## **A14 Cambridge to Huntingdon Improvement Scheme**

### **Written representation and request for an accompanied site visit to the Station Cottages in Huntingdon**

**Dr Jan C. Axmacher, [REDACTED]**  
**REF A14-AFP101**

**SOUTHERN ACCESS TO A14  
WORK NO. 5 - WORKS PLANS SHEET NO. 15**

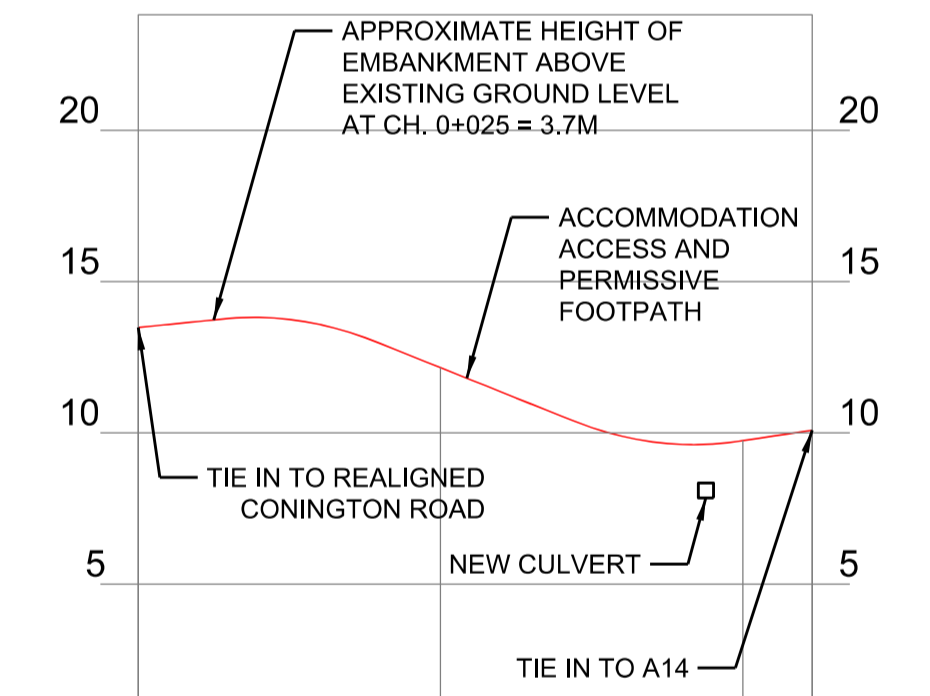
The proposed southern station access road would be located much nearer to the level of and much closer in distance to Station Cottages than the current A14. Furthermore, it would create a significant break in the embankment of the elevated, de-trunked A14 (see e.g. Section MM, Figure 3.3: outline environmental design – Illustrative cross sections, Sheet 11), channeling pollutants resulting not least from the aforementioned traffic congestion on the de-trunked A14 down towards our properties. Planned changes to the de-trunked A14 embankment itself will also severely compromise the current protective screening by trees, leading to a substantial increase in air, noise and light pollution experienced by our properties. Once the planned new embankment planting eventually matures, the channeling of pollutants down the southern station access road towards our property will be exacerbated. The opening in the embankment of the de-trunked A14 at its junction with the station access road, but particularly the traffic moving on the new station access road itself, will overall result in a persistent higher noise and light exposure of our properties.

The embankment on which part of the proposed new southern station access road itself is to be built would effectively create an additional barrier that would 'dam up' harmful emissions around our properties and hinder their effective dispersal. The same will hold true for water-bound pollutants e.g. when surface runoff occurs, but potentially also via groundwater flow. In contrast, the proposed, extremely limited planting indicated along the raised northern side of the southern access road would take years to create even a minimum degree of privacy and protection from light, noise and air pollution for the householders, and is completely inadequate.

More effective mitigation might be gained by building a solid physical structure in the form, for example, of a soundproof screen fence/wall that could also address the substantial security issues associated with opening up the southern boundary of our properties to easy public access, in association with appropriate planting which in time would absorb pollutants and improve the visual appearance.
